RE: ENGINEER CERTIFICATION FOR SUNDANCE PRES. PL. (C17-D1U)
CERTIFICATION STATEMENT DATED 10/7/98

RE: SUNDANCE (C17-D1U) GRADING & DRAINAGE PLAN AND S.O. 19

TRACT B-1-A-2

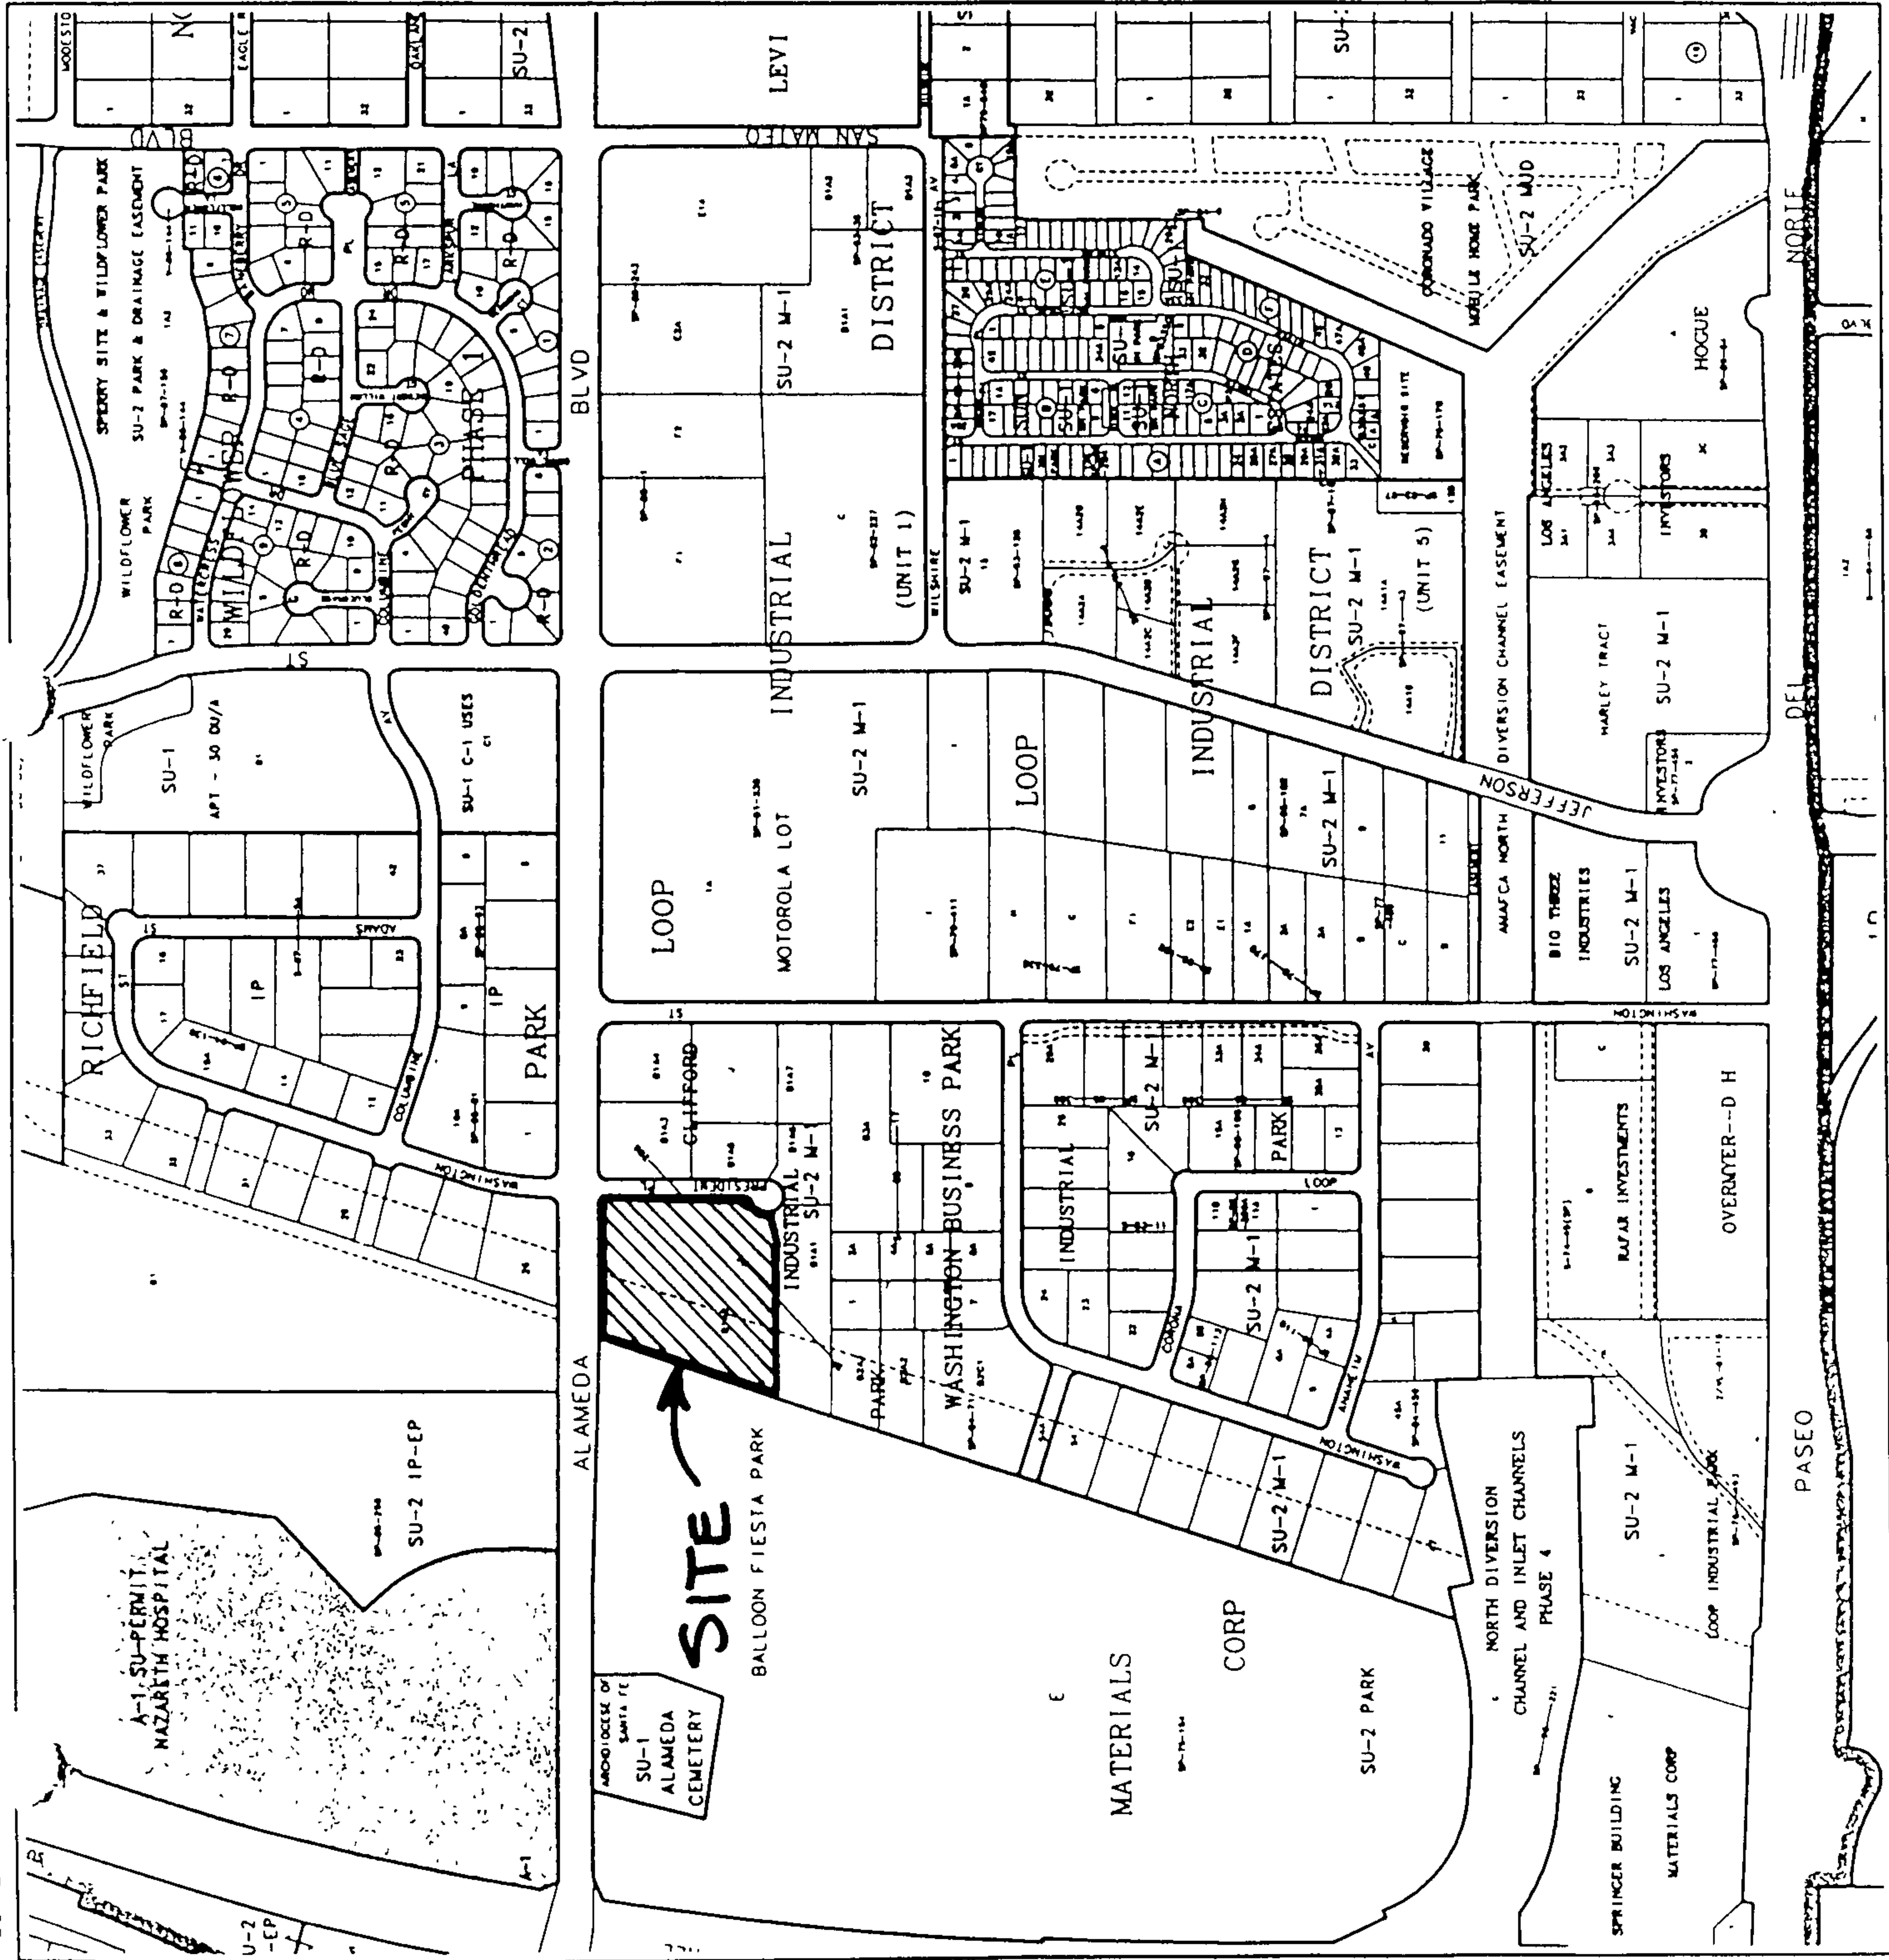
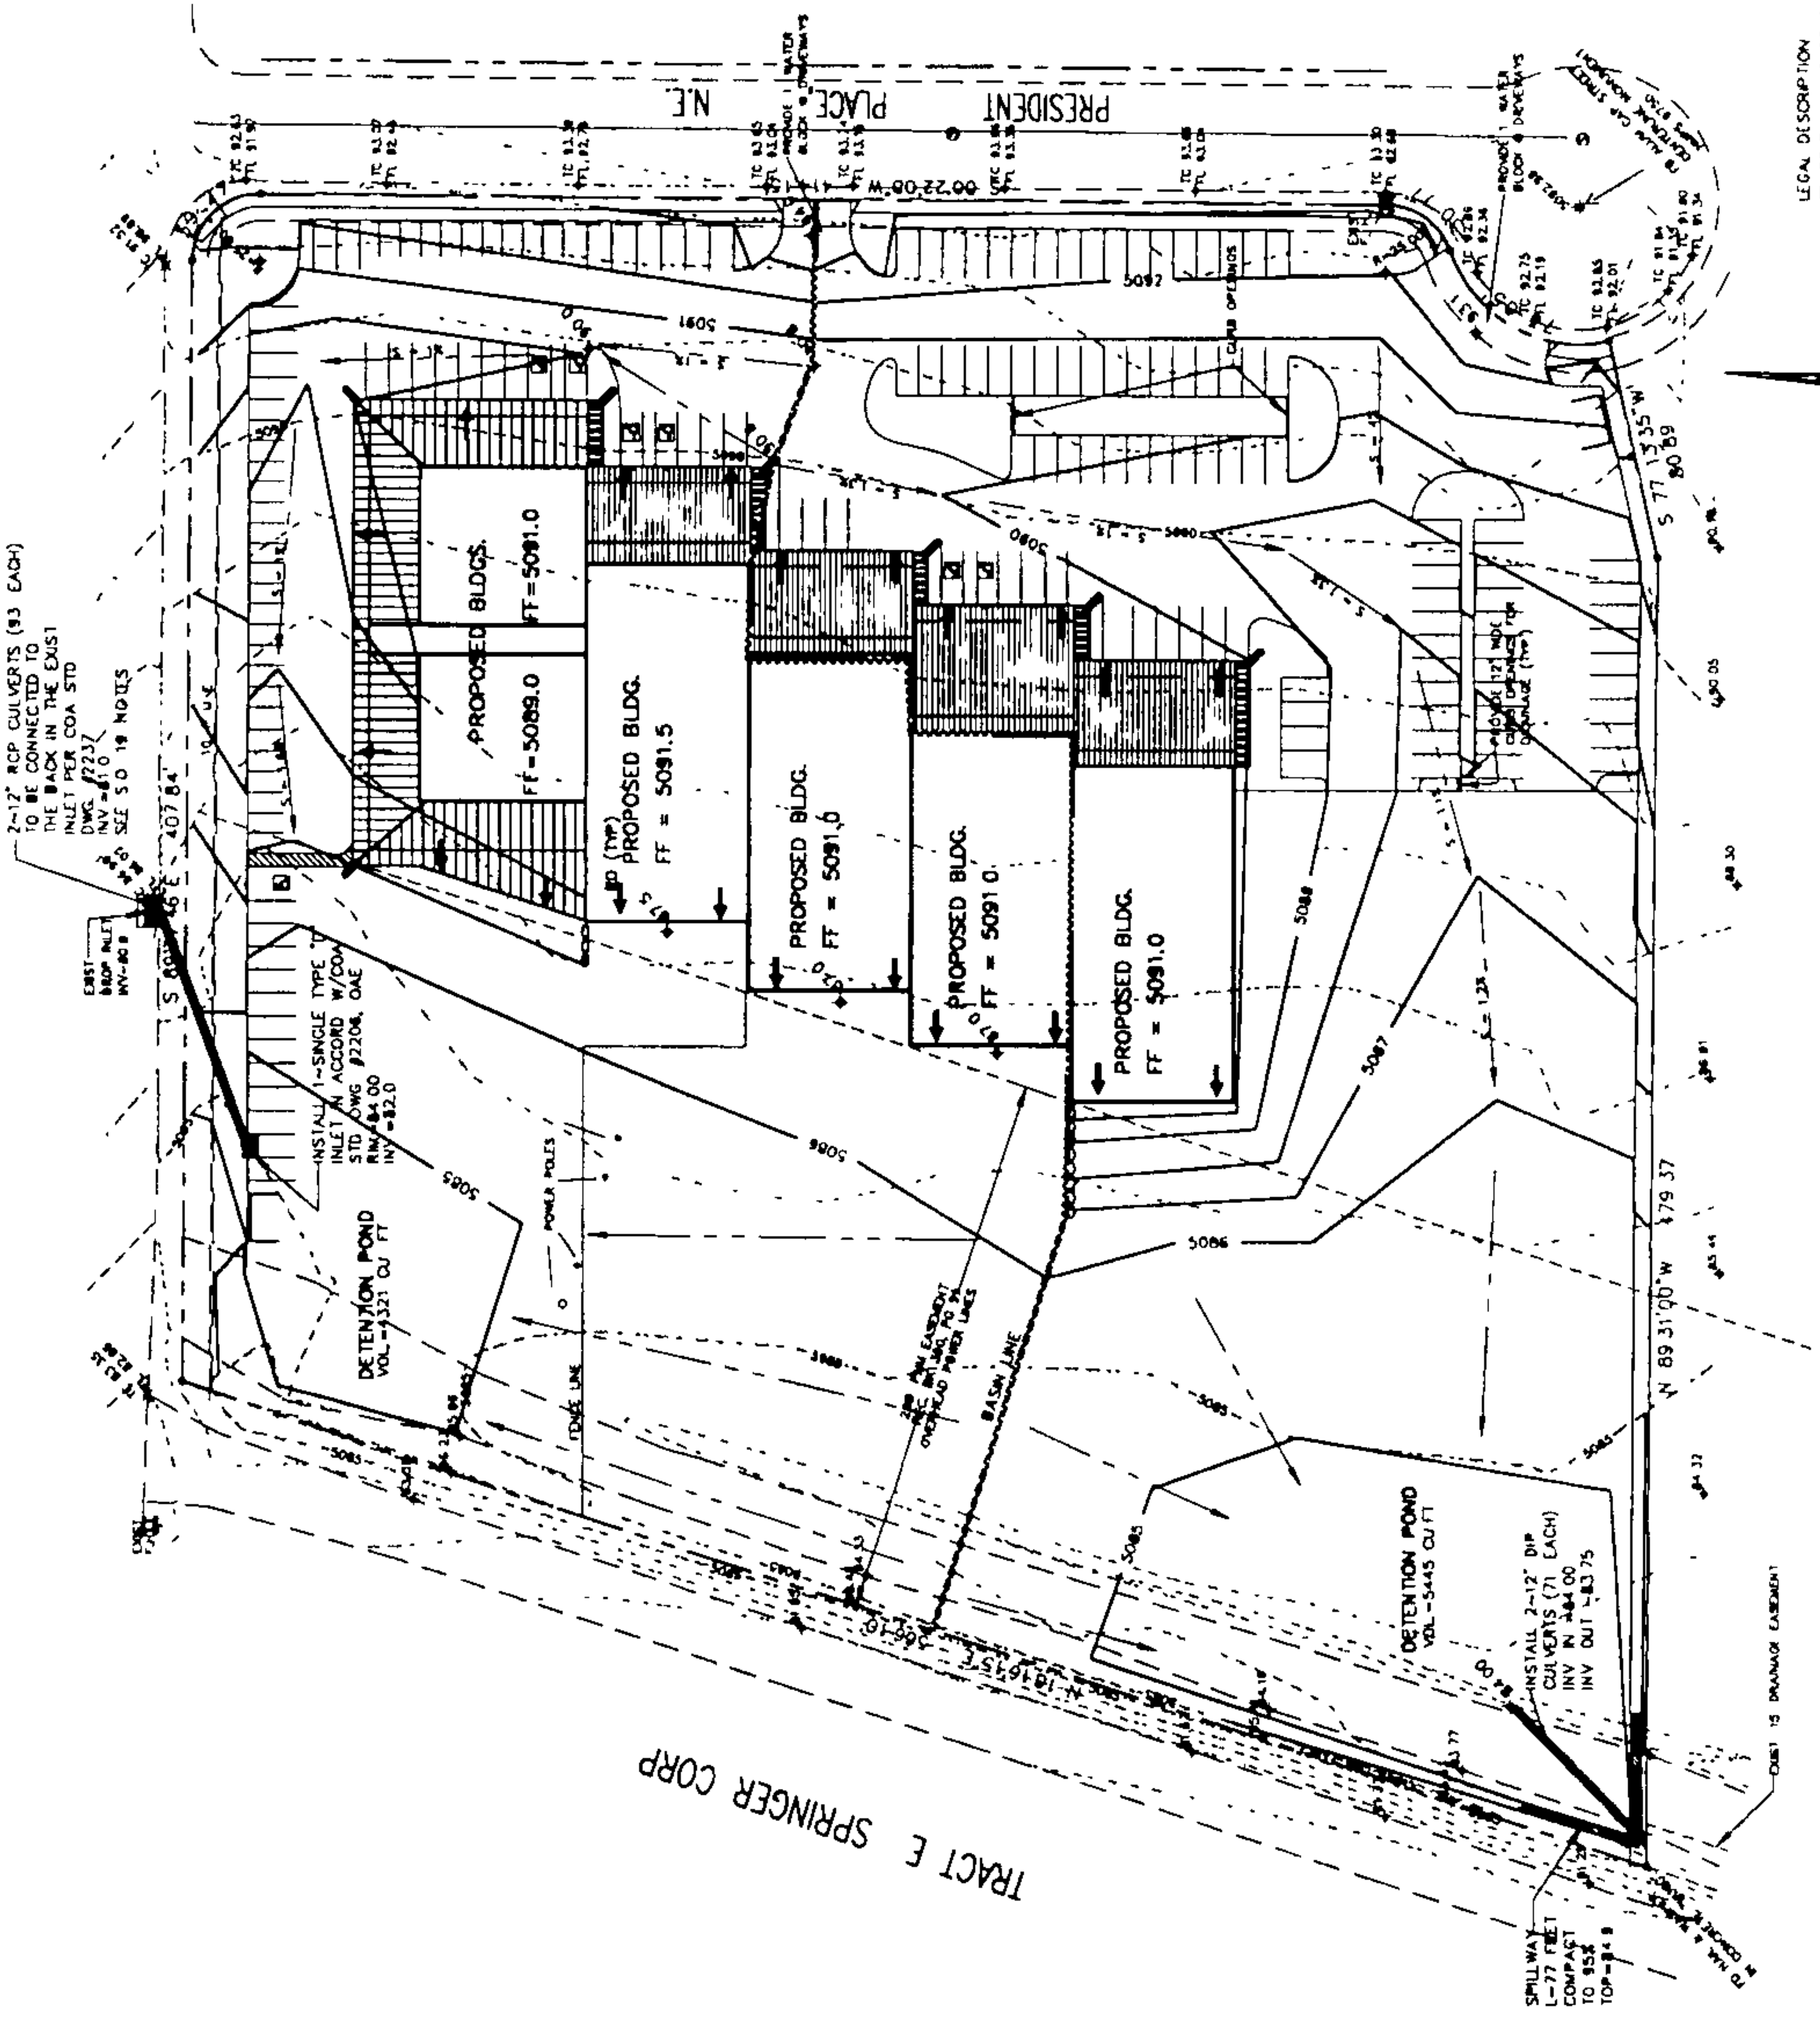
1. Rip rap protection has been added to the pond design and should eliminate sediment from entering the existing concrete channel.
2. We are using 2~12" culverts to tie into the existing inlet in Alameda because of capacity requirements and minimum size requirements shown on the standard detail. The existing inlet is a double "C". We have modified the alignment of the pipes tying into the inlet which comply with the standard detail.
3. A legal size portion of the plat is attached.
